Subject: 2024/93474 at location 35, St John's Rd, Birkby, Huddersfield, HD1 5DX

Please see comments from an ecological perspective for this application:

client	HANSON COURT LTD		
project	RESIDENTIAL DEVELOPMENT 35 ST JOHNS ROAD BIRKBY HUDDERSFIELD HD1 5DX		
drawing	EXISTING FLOOR PLANS (AND DEMOLITION AREA)		
revision	notes	date	drawn
A	DEMOLITION AREA ADDED	03.25	PB
scale :	1:100 AT A1	04.24	PB
project no.	drawing no.	revision	
2327	01	A

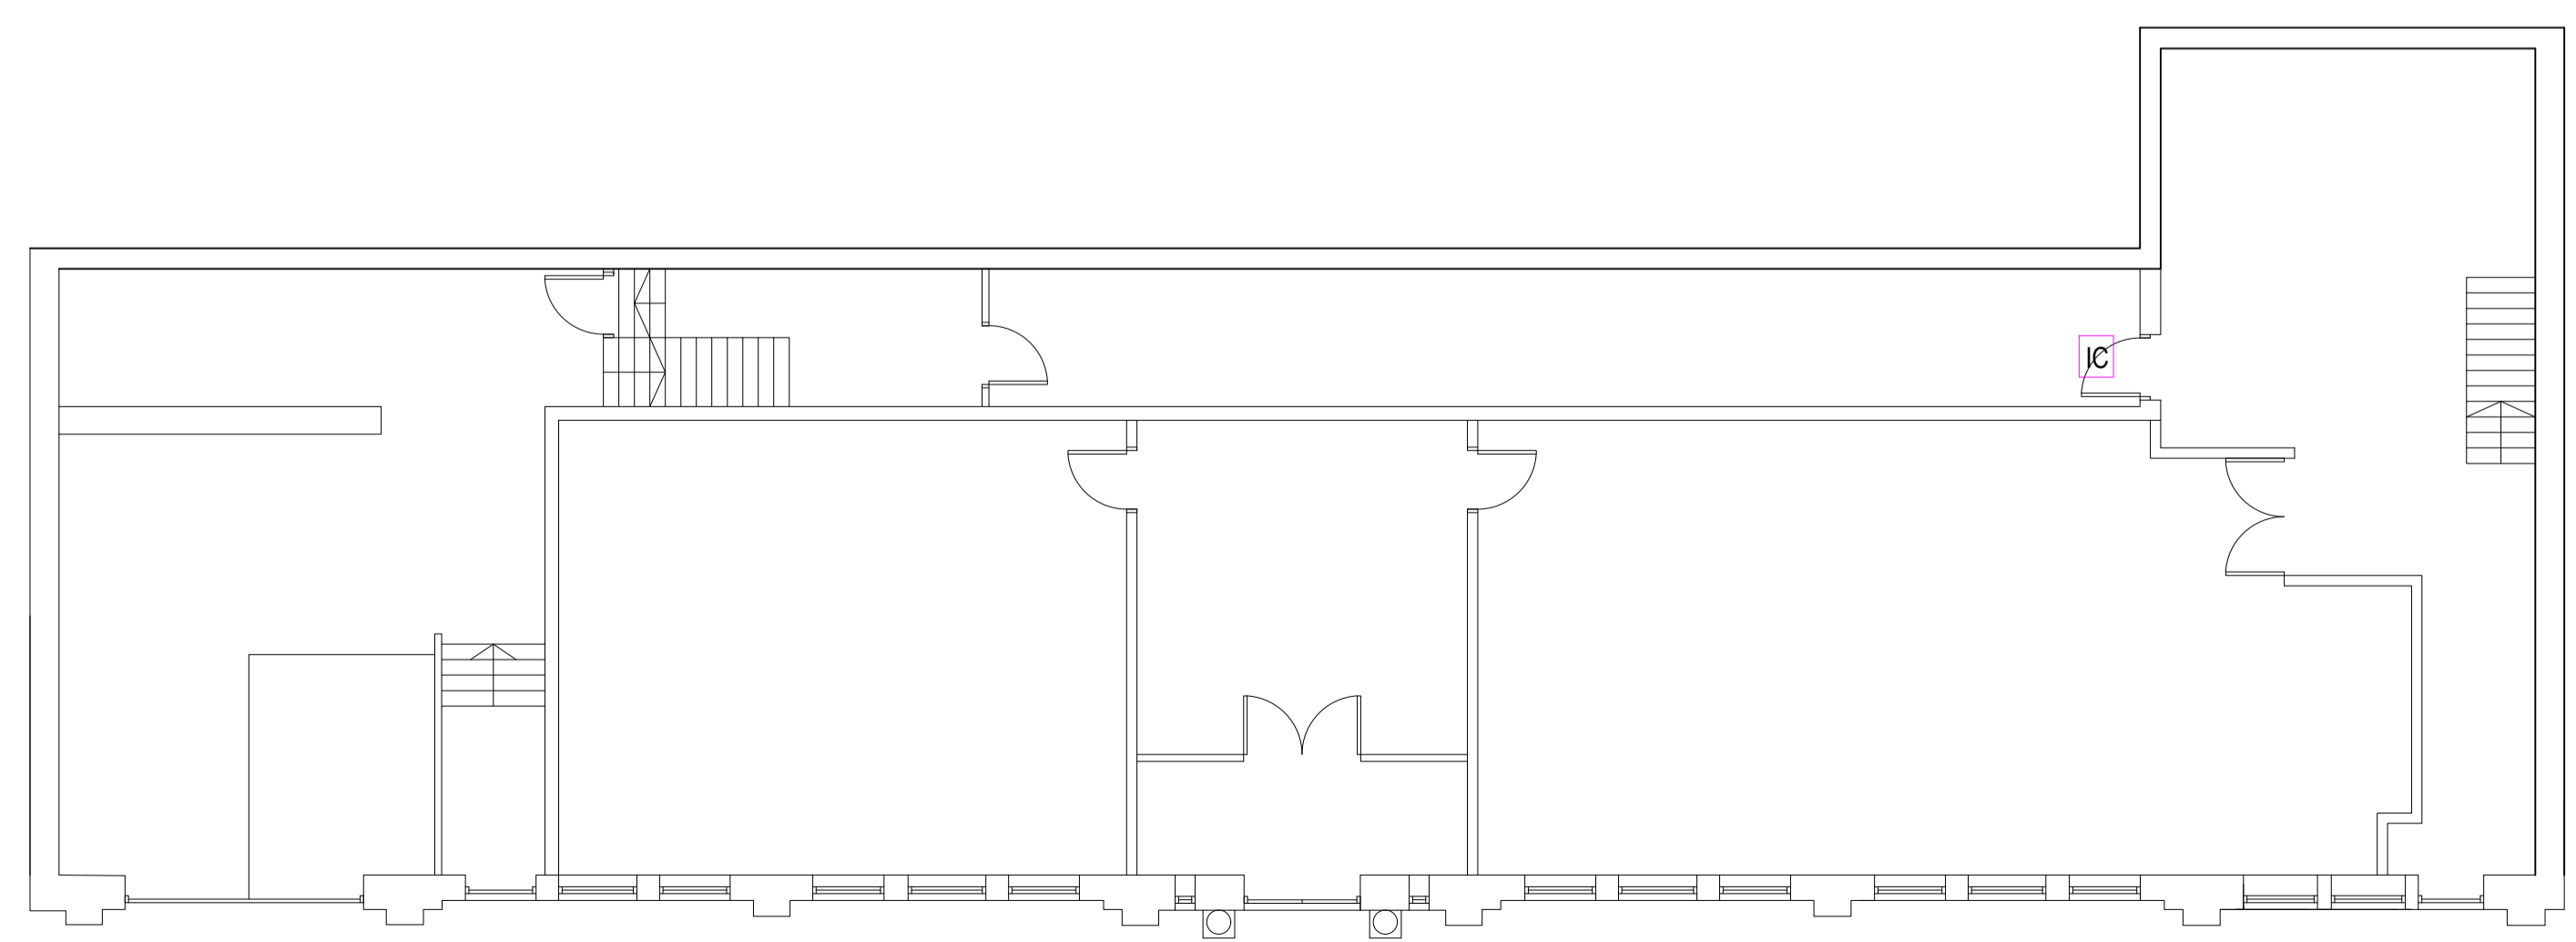
It does not appear from drawings and aerial photographs in the bat survey report that an extension is to be included in the design. As a result, for now, Biodiversity Net Gain is exempt as set out in Schedule 7A of the Town and Country Planning Act 1990 (as amended).
